PO Box 90  
Culburra Beach NSW 2540

**West Culburra Part 3 A mixed-use subdivision. Application MP 09\_0088 Culburra Rd.  
Concerns regarding the Response to Public Comment.**

### LWPA concerns regarding “Environmental Assessment Response to Submissions” John Toon Pty Ltd

Plan 1: The West Culburra Mixed Use Concept Plan

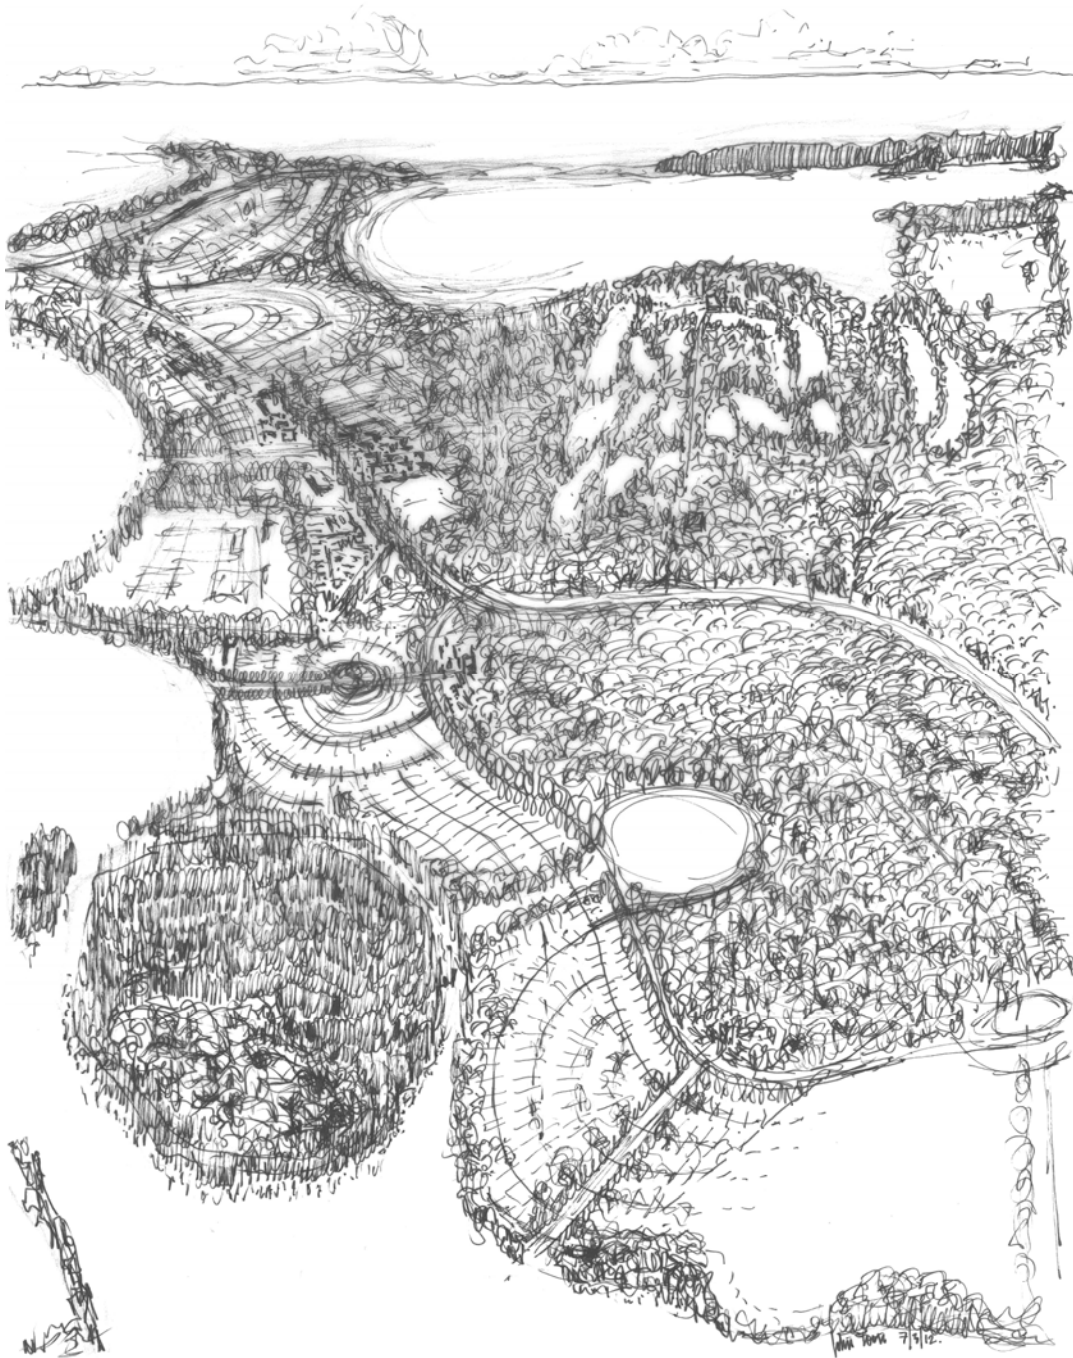
There is no way of knowing the extent of the claimed reduction in residential development in the central section in the Crookhaven catchment, as the TR does not map the change or provide details of the number of lots reduced.

**LWPA proposed that no residential development be proposed in the central area, to protect adjacent wetlands, to provide a green corridor both for passive recreation and to provide a wildlife corridor. However the TR does not mention our objection to the unbroken extent of residential development or comment on the suggested changes.**

9. The foreshore cycle/walkway

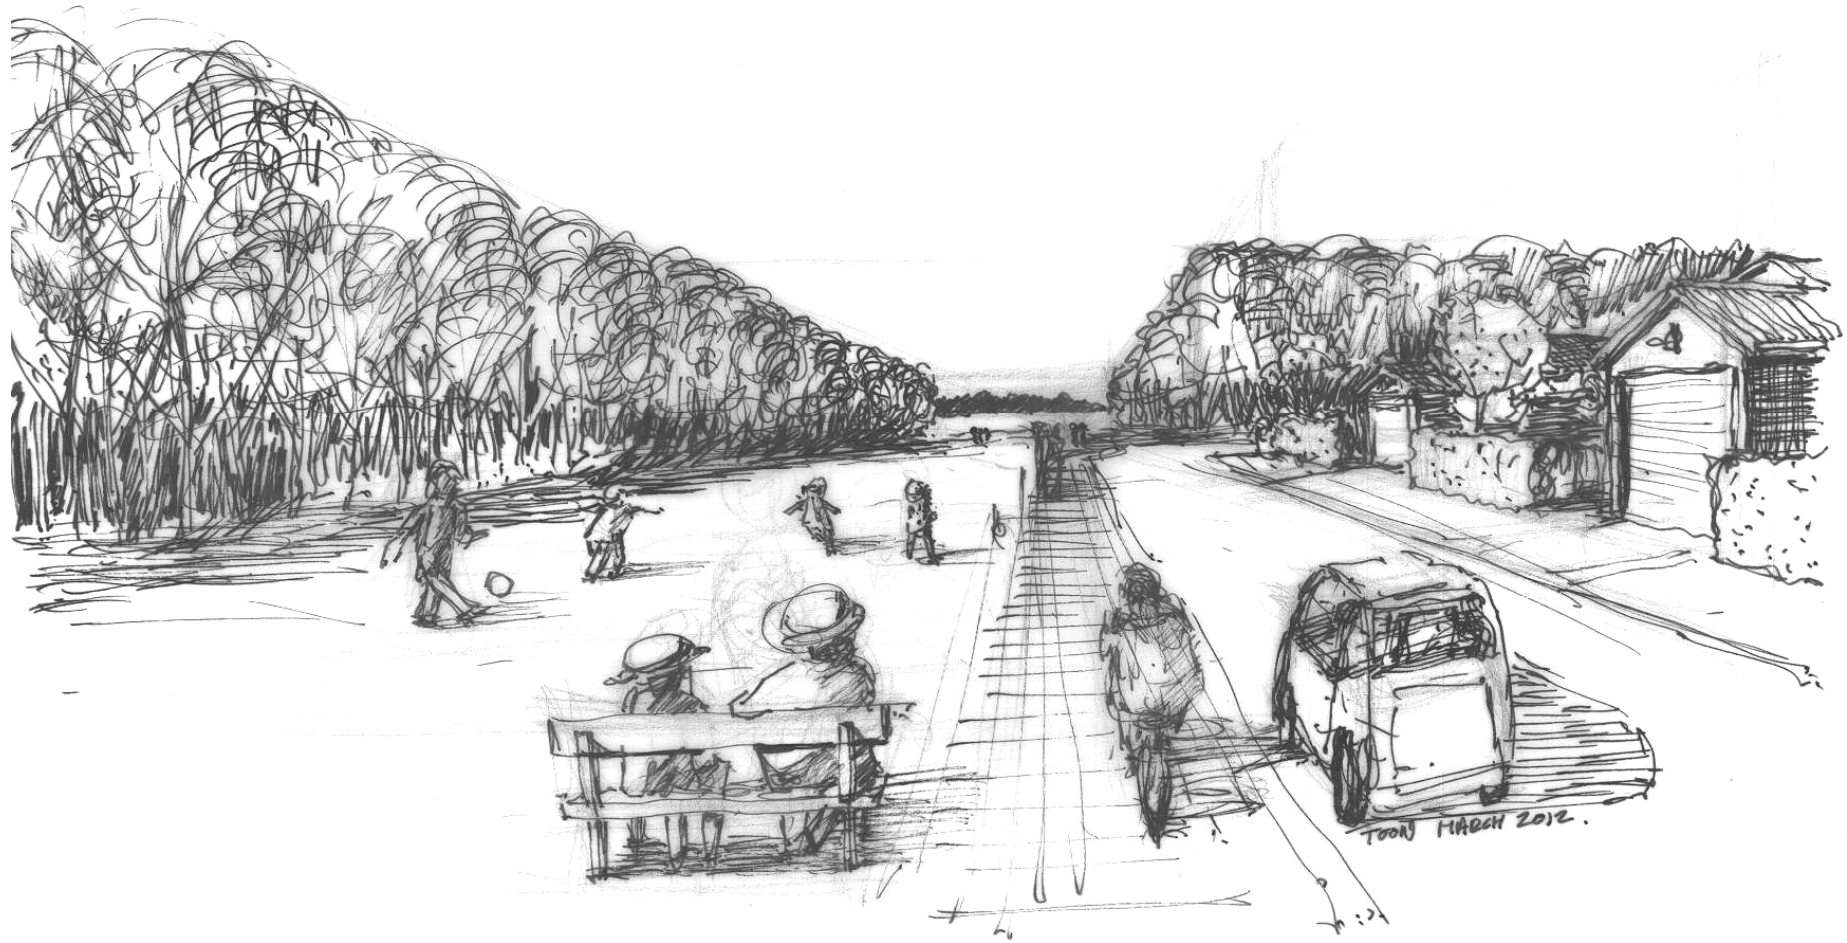
In our view the proposal for a cycle/walking track within the wetland and for its full length would result in substantial degradation of the wetland. These impacts could be significantly reduced and the management measures more effective if the route was located directly south of the wetlands along the existing main sewer line and adjacent to the proposed Foreshore Drive.

**We recommended and continue to recommend that the location of the bike/walking track and exercise facilities be shifted out of the Crookhaven River-Curley’s Bay SEPP 14 wetlands and Environment-zoned areas and located immediately south of the wetland and adjacent to the Foreshore Drive along the northern perimeter of the subdivision. We also proposed that limited side tracks into the wetlands be provided, together with appropriately located seating and interpretive signage. Barbeques and children’s play grounds should be located outside the wetland perimeter.**

- relocating the cycle/walkway immediately south of the wetland adjacent to the northern most road as explained at Page 4 of this submission. This shift would limit damage and loss of wild life habitat from construction and increased population using the cycle/walking track, particularly motor bike and off-road motor bike riders who would inevitably be encouraged by such a long track out of public view.
